The Department of Planning and Environment
Major Projects.
Via majorprojects.planning.nsw.gov.au and
Plan_comment@planning.nsw.gov.au

Submission Albion Park Rail bypass, Environmental Impact Statement, 2015.

# Map 3 - Southern Interchange

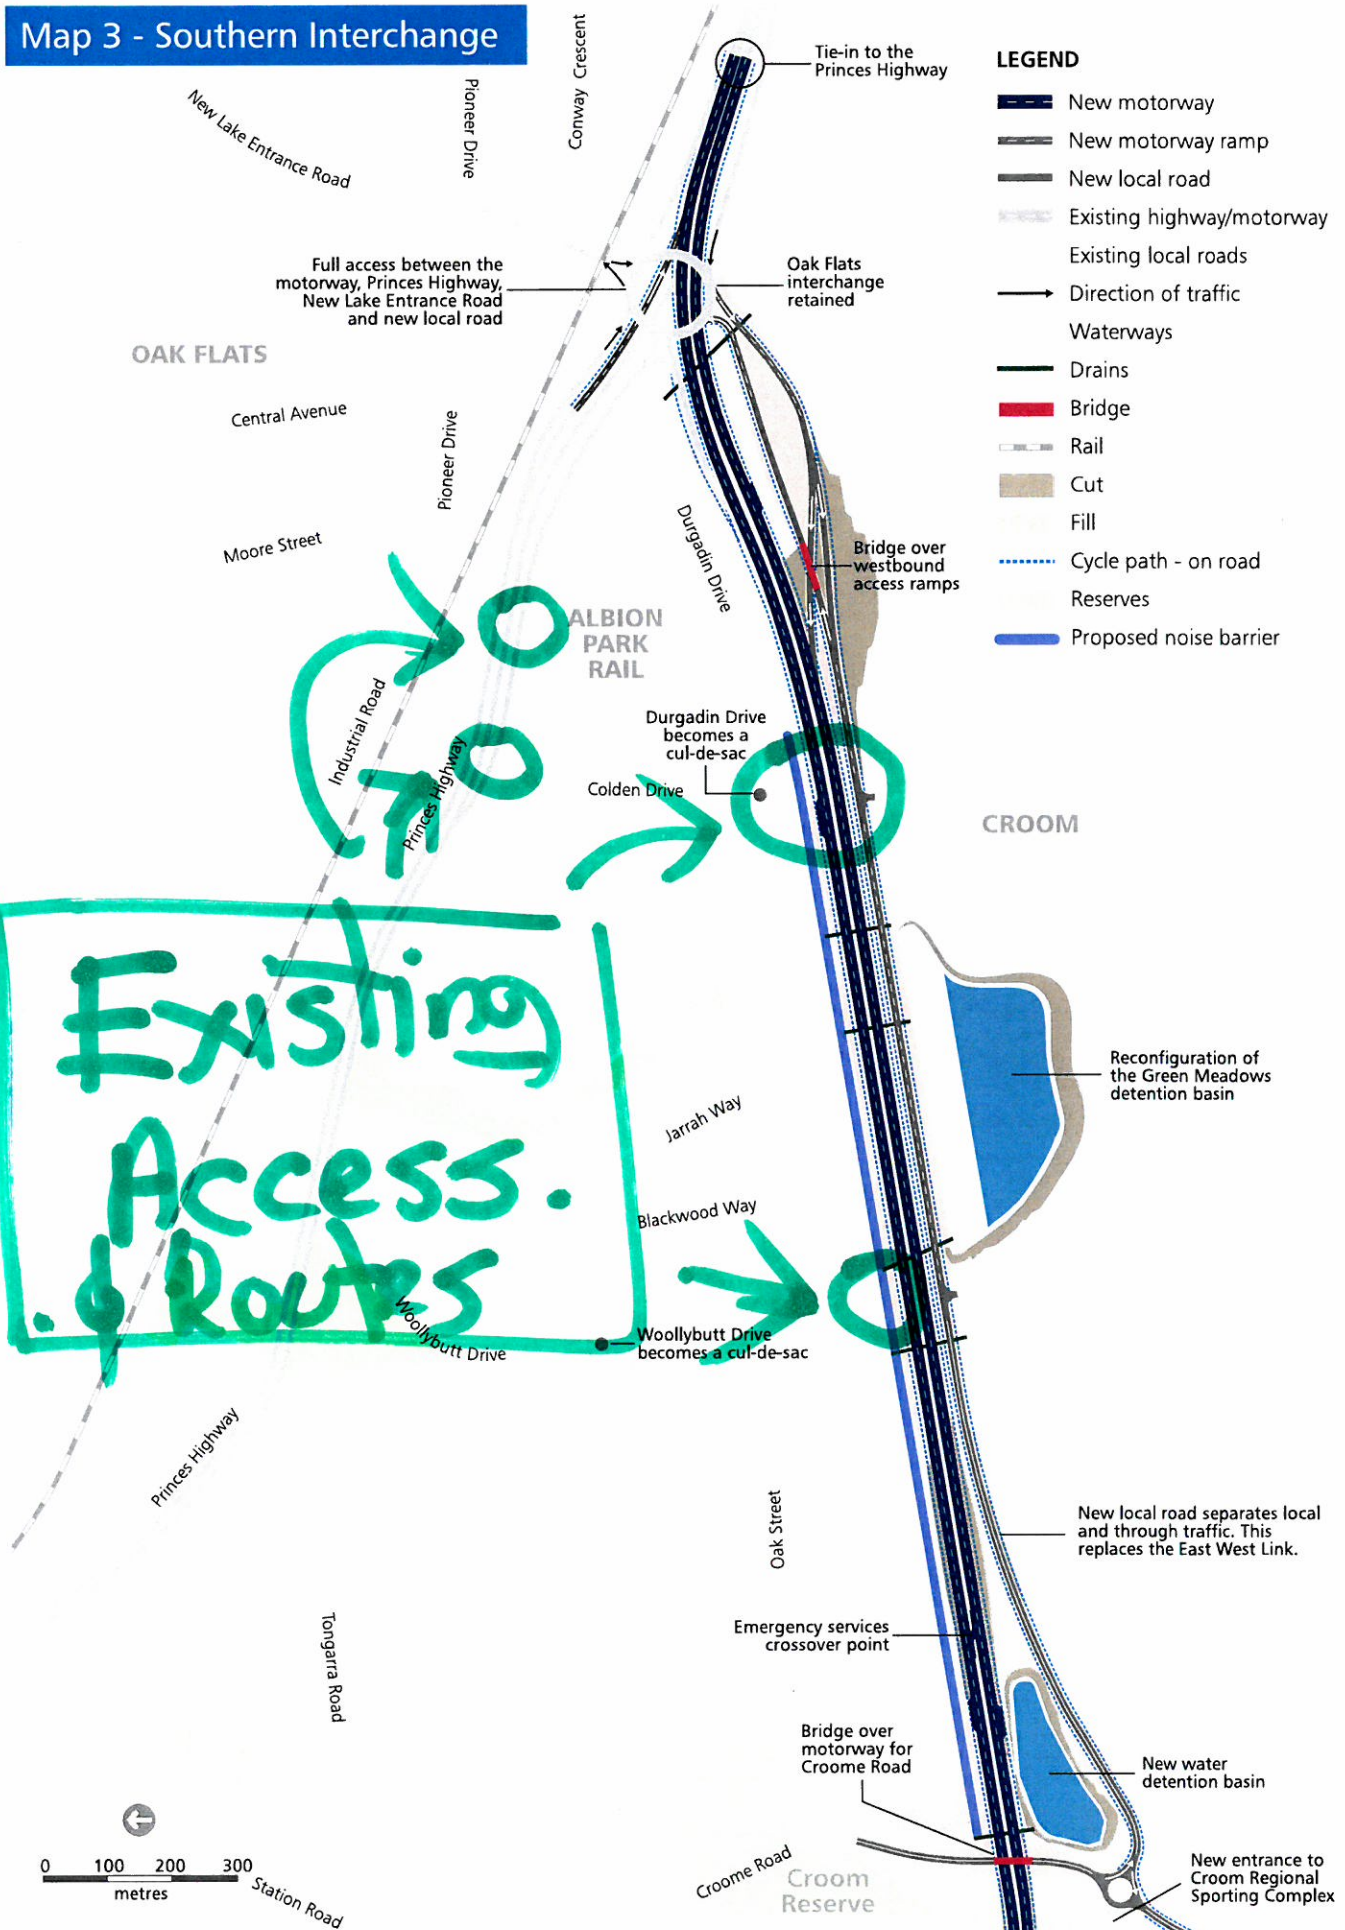
There is an Explanation of the Southern Interchange Map 3, page 8

There is NO Explanation of the area surrounding Haywards Bay, Yallah area. This missing portion which in the view of the EIS does not require a detailed explanation contains the majority of residents. Who could be misled into thinking that there are no issues affecting them as there has not been a detailed explanation. If there are no concerns no one would go and read an additional 650 pages.
